PLANNING CONSULTATION RESPONSE

Application No	2026/0292
Proposal	External alterations and installation of doorway to provide level access, as well as internal alterations including installation of platform lift and extension of ATM room.
Address	26 Market Hill, Barnsley, S70 2QE
Date of Consultation Reply	27.05.2026
Consultee	Charlie Atkinson Design & Conservation Assistant

Project: **Level Access Program**
 Title: **Barnsley Proposed Plan & Elevation**
 Client: **NatWest Group**
 Purpose: **For planning**
 Drawing Number: **7119-JMA-14-00-DR-A-000012**

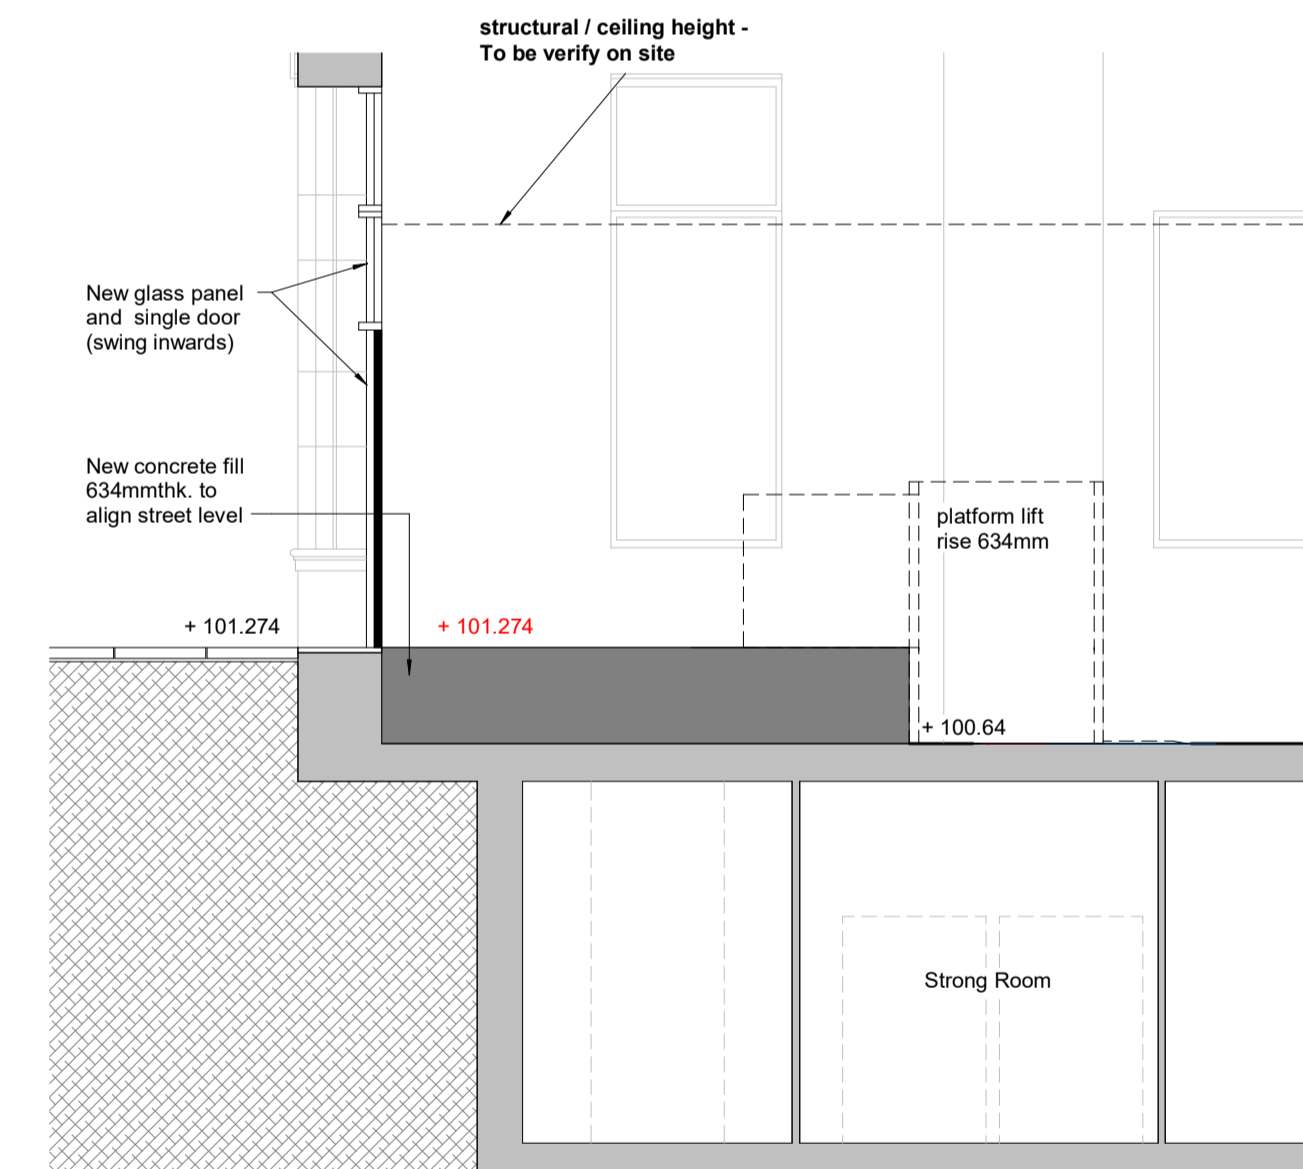
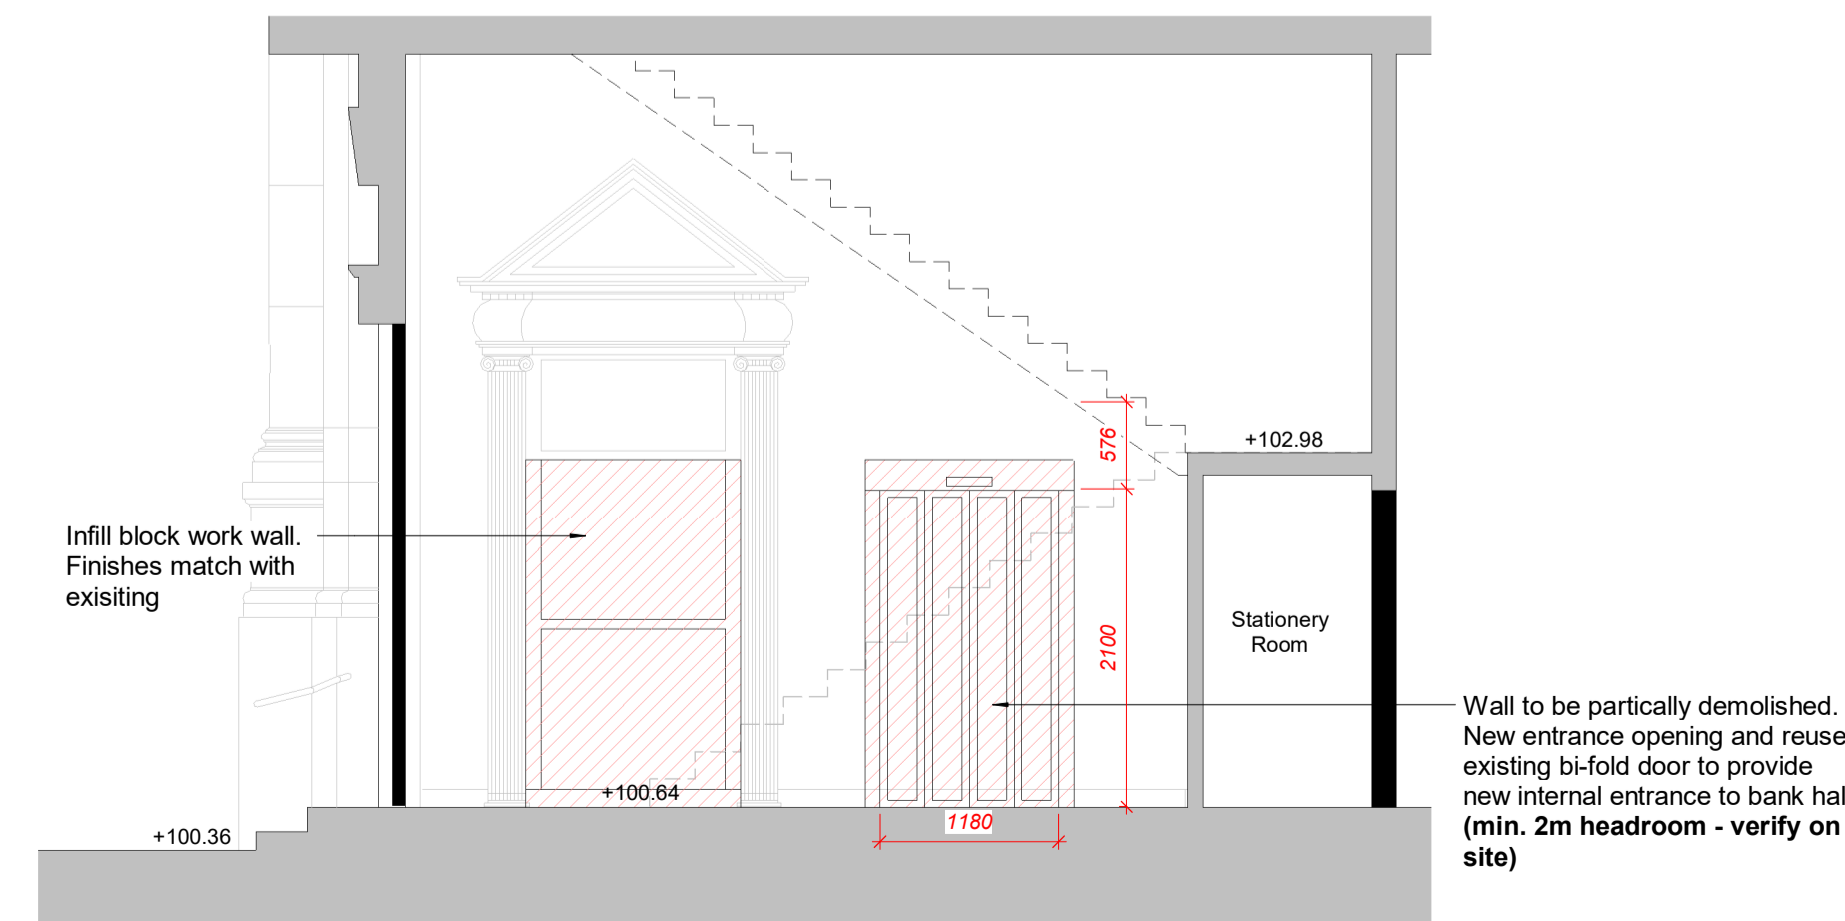
Whilst the interior of the building holds some interest, the proposed internal alterations are limited to modern partitions and therefore do not raise significant conservation concerns. The primary consideration from a conservation perspective is the alteration to the external fabric including the conversion of an existing ground floor window (first from the left) into a doorway, resulting in the loss of a section of low-level stonework. This intervention is relatively minor in scale, and the justification in terms of improving accessibility is considered to outweigh the very little impact, supporting the continued use and viability of the building. However, further detail should be provided in respect of the design and detailing of the proposed doorway, ensuring that it sits comfortably within the existing opening in terms of proportions, materials and colour.

Consequently, the proposal is not considered to result in harm to the significance of the conservation area or nearby listed buildings and is therefore recommended for approval from a conservation perspective subject to the above clarification.
